Our ref: NA/2019/114837/04-L01
Your ref: TR010031
Date: 09 June 2020

**PLANNING ACT 2008 – SECTION 88 AND THE INFRASTRUCTURE
PLANNING (EXAMINATION PROCEDURE) RULES 2010 – RULE 6.
APPLICATION BY HIGHWAYS ENGLAND FOR AN ORDER GRANTING
DEVELOPMENT CONSENT FOR THE A1 BIRTLEY TO COAL HOUSE
IMPROVEMENT SCHEME (EXQ3 - DEADLINE 8) NZ2590258148 A1 BIRTLEY
TO COAL HOUSE**

The Examining Authority's further written questions and requests for information (ExQ3)

Drawing 2 – Illustrative elevation of 3-span viaduct design

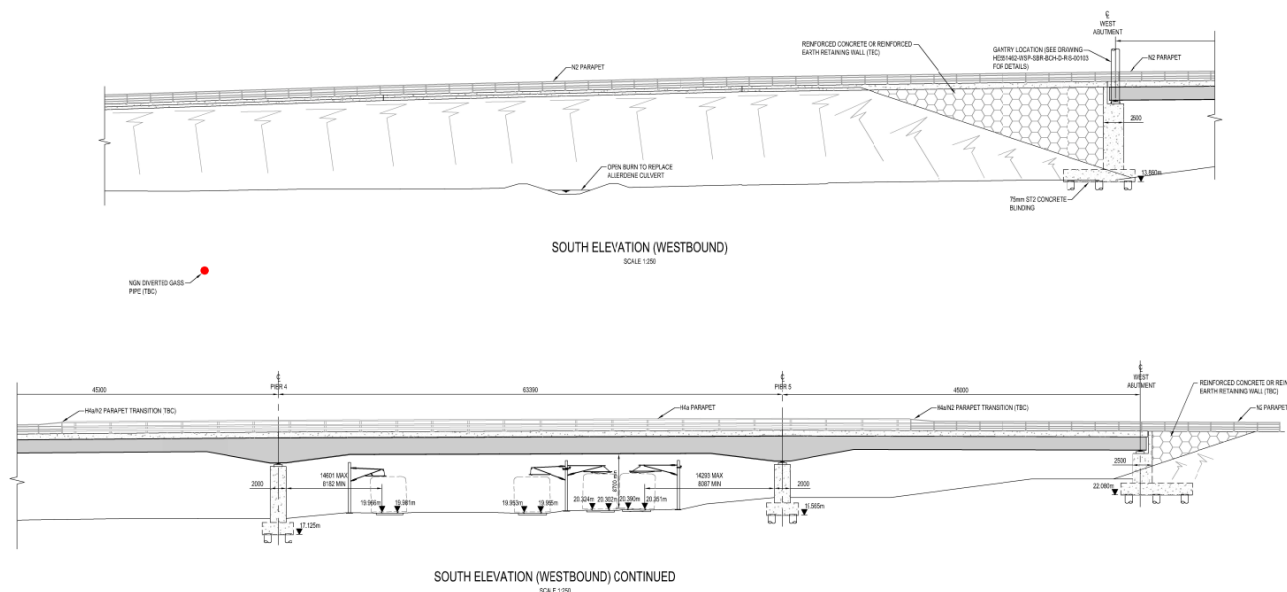
With respect to the Allerdene three-span viaduct option, from a Water Framework Directive (WFD) and a biodiversity perspective, this is considered to be a backward step for the environment compared to the 6/7 viaduct option. Further WFD and biodiversity mitigation will be required to compensate and mitigate the WFD and biodiversity impacts of the three span bridge option. As the EA will be consulted on the CEMP and involved in the detailed design of the Allerdene Burn culvert, we will be able to ensure that appropriate mitigation measures are implemented to mitigate against any WFD or biodiversity impacts arising from the Allerdene three span viaduct option through this process. For clarity, we will not be providing any further comments regarding this matter or the additional land option.

2.2 We also have a role in relation to maritime archaeology under the National Heritage Act 2002 and advise Government in relation to World Heritage Sites and compliance with the 1972 Convention Concerning the Protection of the World Cultural and National Heritage.

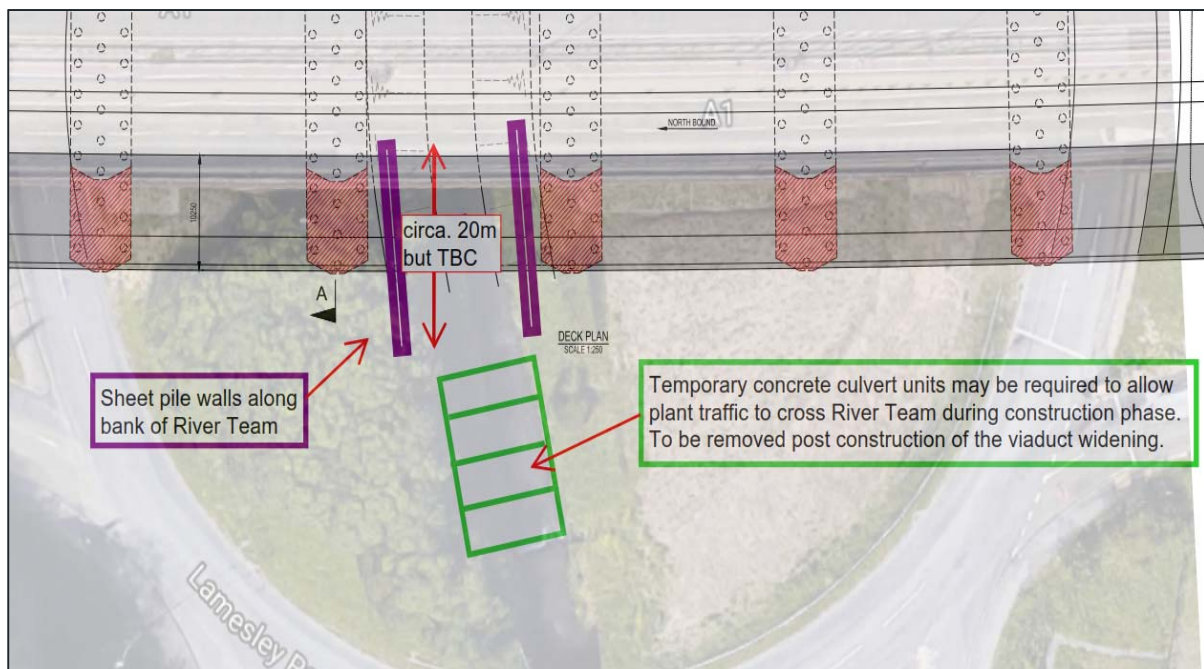
With respect to reference B10, this section states that the 'Pre-construction placement of the temporary underground culvert within the River Team within Coal House roundabout will be undertaken outside the period of October to May to avoid the salmon and brown trout (migratory and non-migratory) spawning periods. This will be agreed with the Environment Agency'. We support this measure. However, we would welcome the inclusion of the word 'inclusive' after the word May so that the sentence states 'outside the period of October to May inclusive'.
